MARIST COLLEGE NORTH SHORE REDEVELOPMENT PLANS

Would you please answer the following questions in relation to your design:

Undercroft Area - Plan

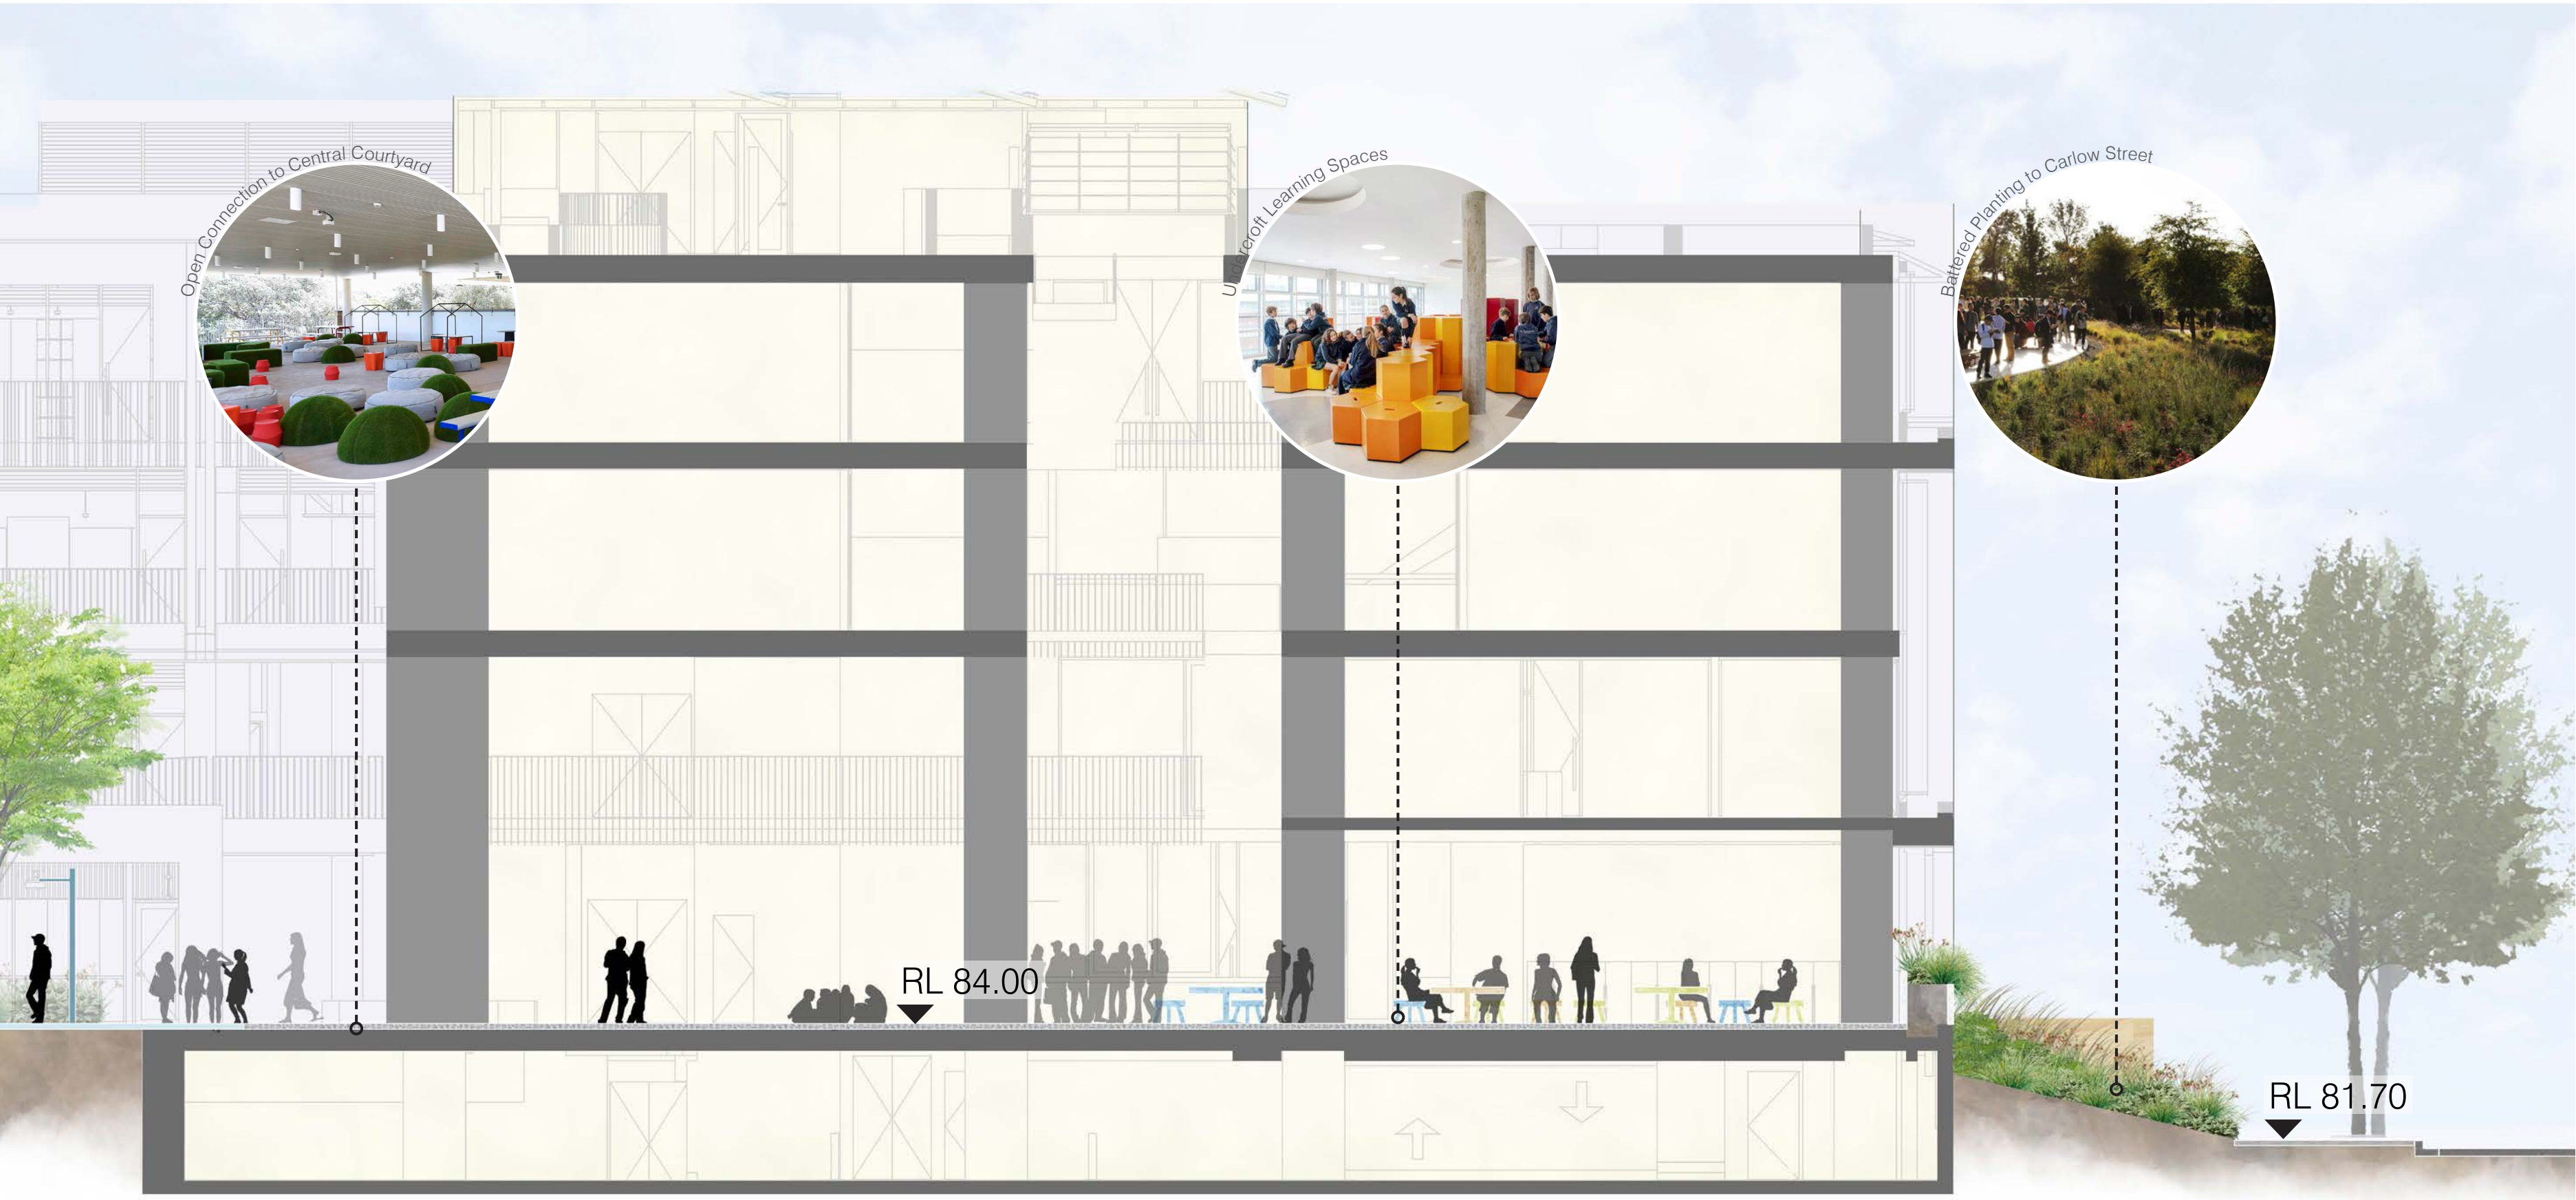
7. **Are you proposing large native trees such as flowering gums, firewheel trees (like in other parts of Carlow Street) and lemon scented gums?** Given the proposed substantial four storey building height over the basement car park, substantial landscaping with large (non-deciduous) tree planting is necessary in order not to affect the street ambience viewed from the residences in Carlow Street!
